## Engineers Comments Regarding Surface Water Drainage

<b>Application Reference:</b>	BE/48/25/PL	<b>Reviewer Reference:</b>	ADC/EXT4
<b>Planning Officer:</b>	Amber Willard	<b>Date of Review:</b>	20/08/2025
<b>Site Name:</b>	Rear of Regal House And Wayside Shripney Road Bognor Regis PO22 9NP		
<b>Application Description:</b>	7 No. residential dwellings and associated works including new access. This application is a Departure from the Development Plan and is in CIL Zone 3 and is CIL Liable as new dwellings.		
<b>Assessment Number:</b>	2 of 2

Tank Structure at Manhole S2

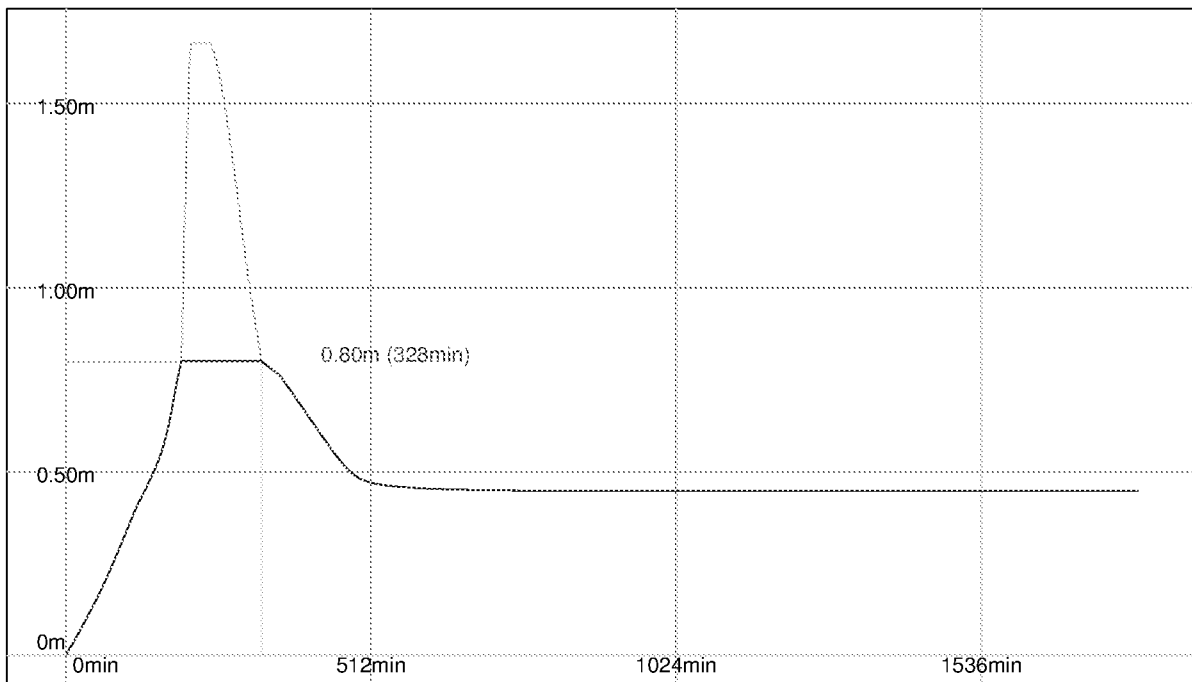
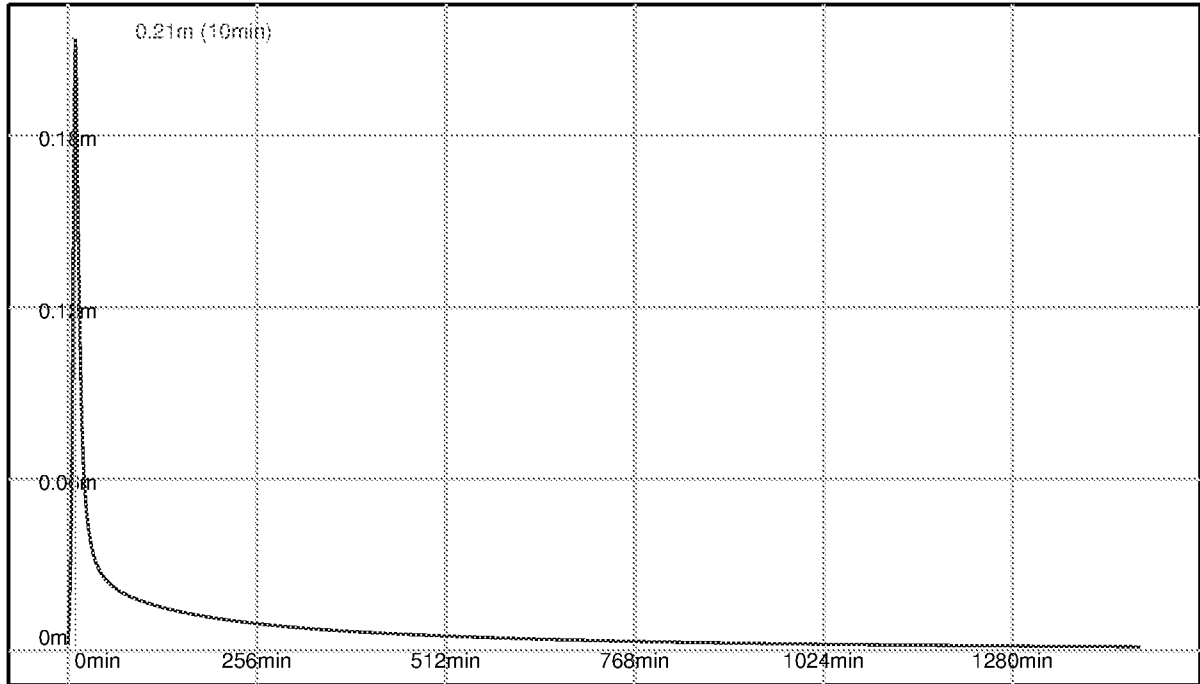
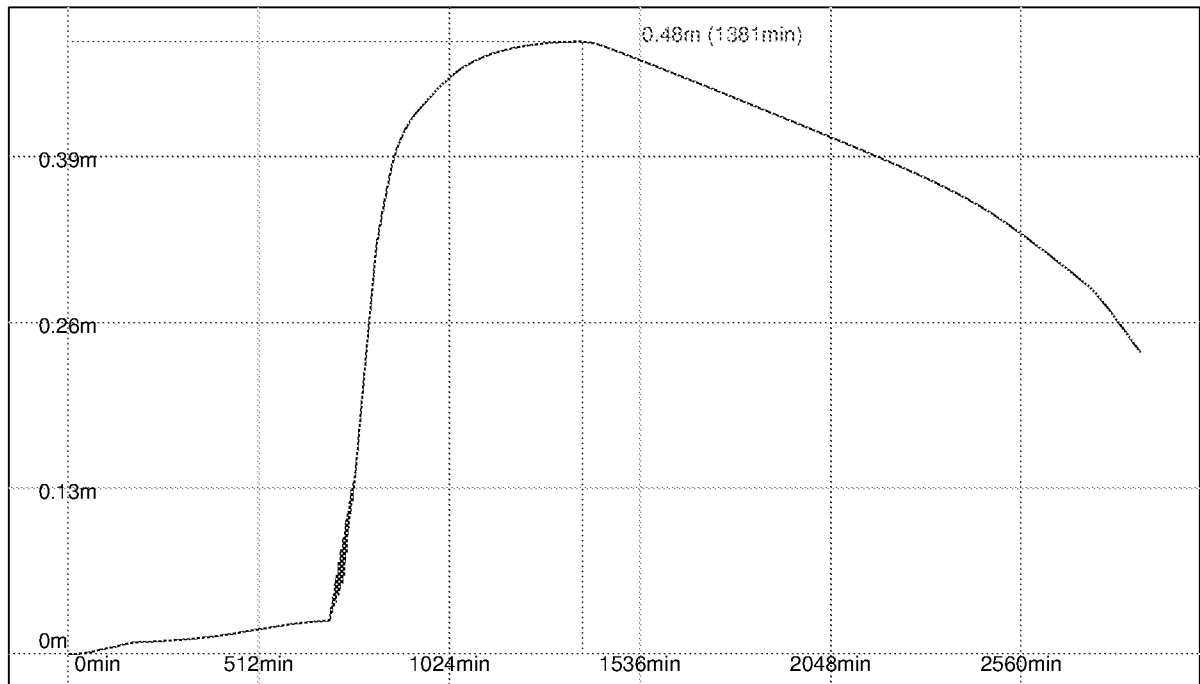
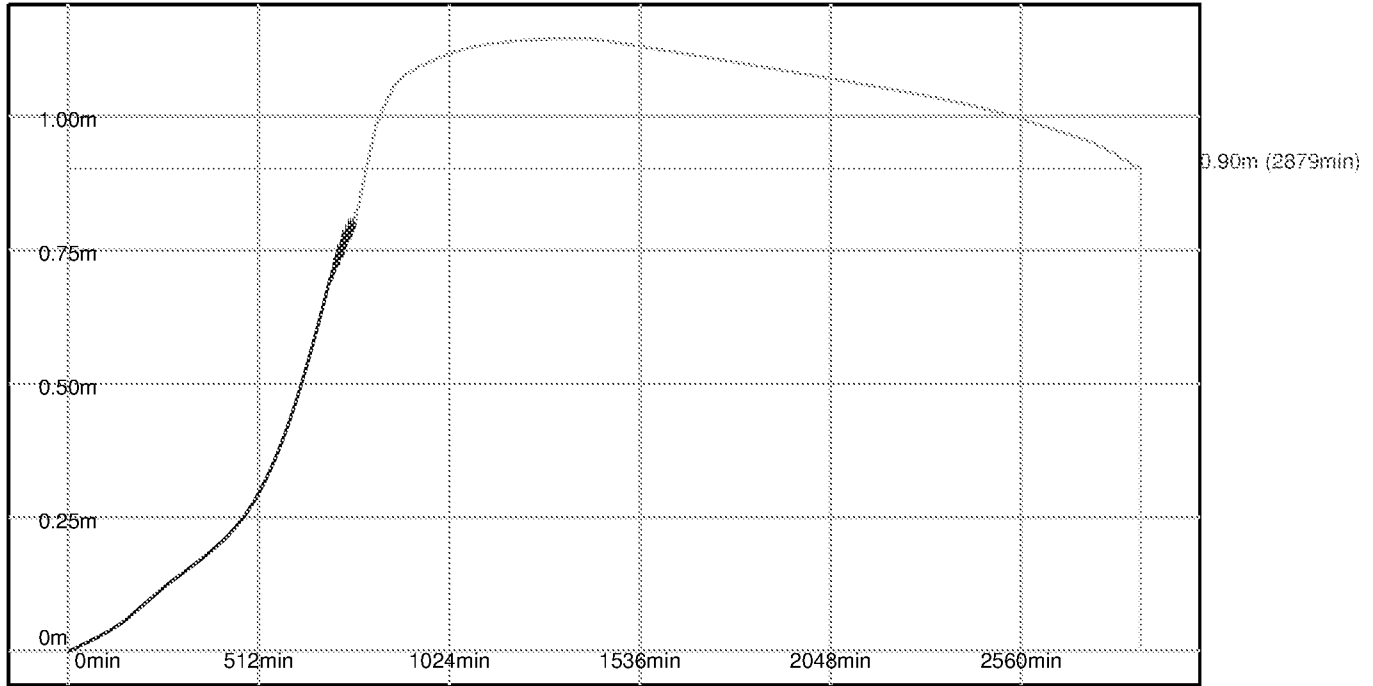
<p><b>Plans</b></p>	<p>Plan areas, depths and levels of drainage infrastructure must accurately correspond with the supporting calculations.</p>	<p><b>Insufficient</b> Drainage plan indicates Geocellular soakaways for both catchments but calculations suggest these are attenuation tanks-please clarify. Tank depths/Invert Levels do not match calculations-please clarify.</p>
<p><b>Water quality benefits.</b></p>	<p>An assessment of water quality is necessary to evidence that the proposed design provides adequate treatment of surface water.</p>	<p><b>Not supplied</b> No details are provided of water treatment to catchment A. The applicant will need to consider to provide a form of surface water treatment for run-off from this catchment</p>
<p><b>Biodiversity and amenity benefits.</b></p>	<p>The surface water drainage design must provide biodiversity and amenity benefits.</p>	<p><b>Not supplied</b></p>
